From: [REDACTED]
Sent: 28 June 2024 13:11
To: Planning
Subject: App 3/2024/0239 Moorcot 24 Nickey Lane Mellor - Ecology Unit Response

App 3/2024/0239 Proposed construction of new two-storey three-bedroom dwelling in garden, with new access and associated alterations to original dwelling, Moorcot 24 Nickey Lane Mellor

Drawing Title
PROPOSED SITE PLAN

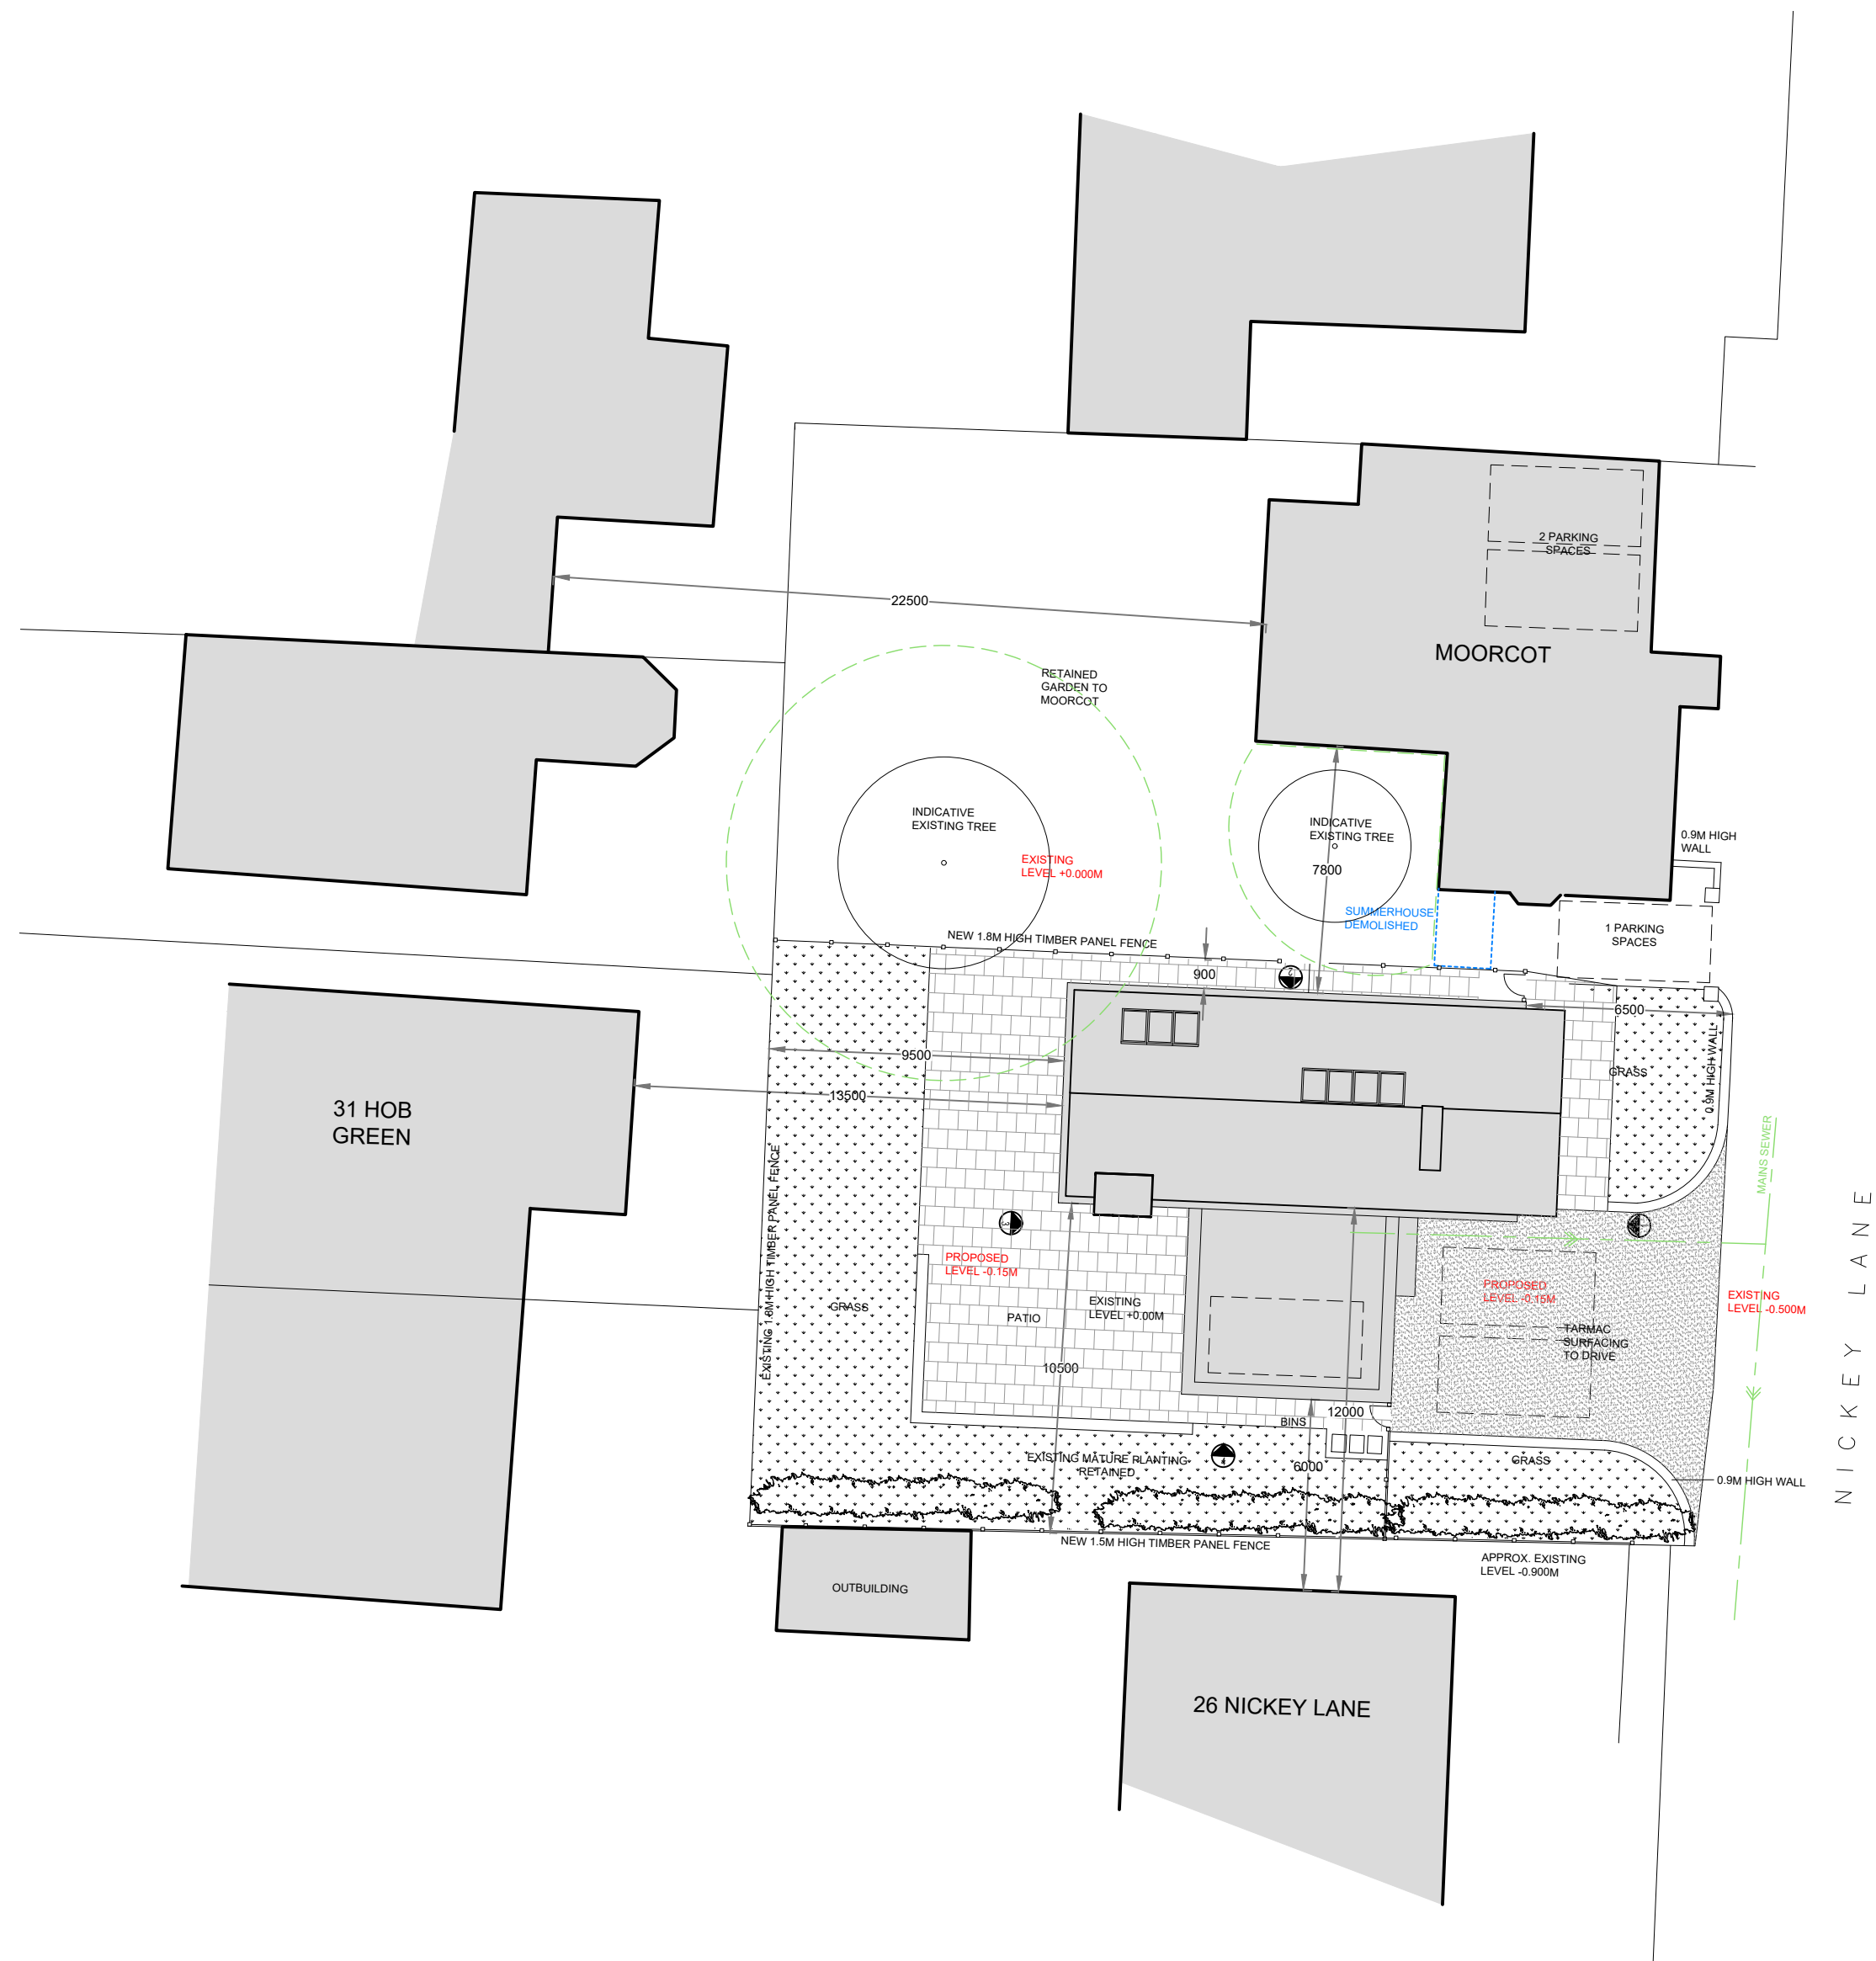
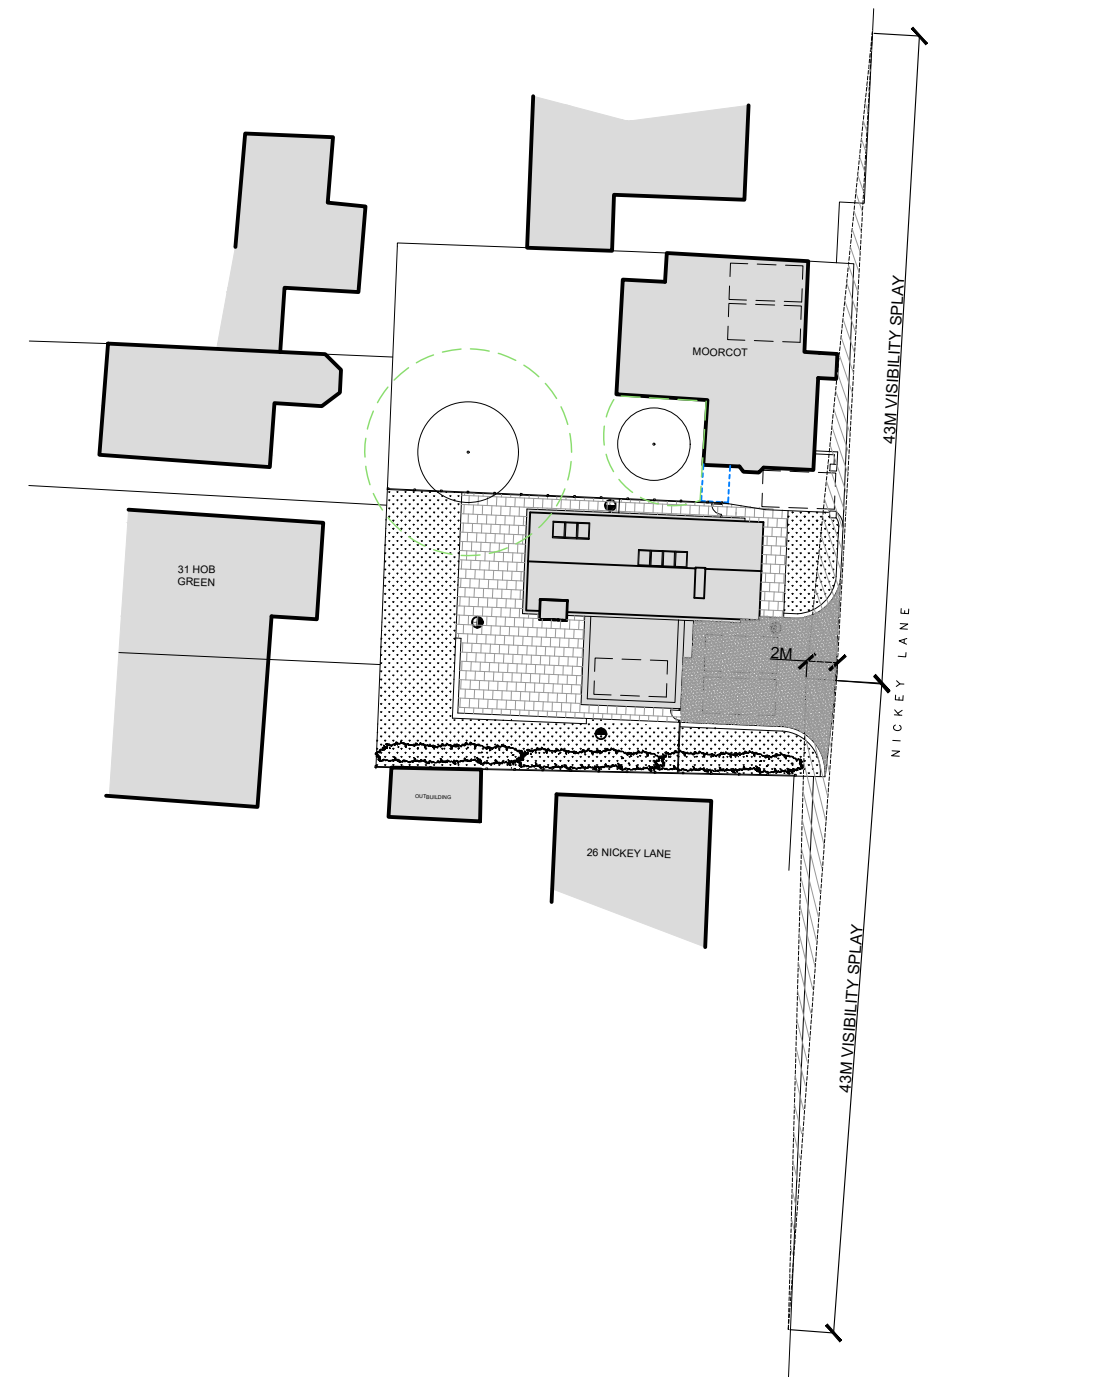
The application involves the loss of an area of garden, including a length of established hedgerow.

- The proposals will result in a loss in biodiversity. In order to achieve a required net gain in biodiversity, further on-site landscaping and/or off-site habitat creation or enhancement will be required. Since the the required habitat gains are relatively small, and the habitats which are subject to the gain requirement are relatively simple and widespread, I have a high level of confidence that the necessary gain could be achieved. In this circumstance I would advise that the standard BNG Condition could be applied to any permission which may be granted to the application, to require the submission of a detailed BNG Gain Plan prior to work commencing.
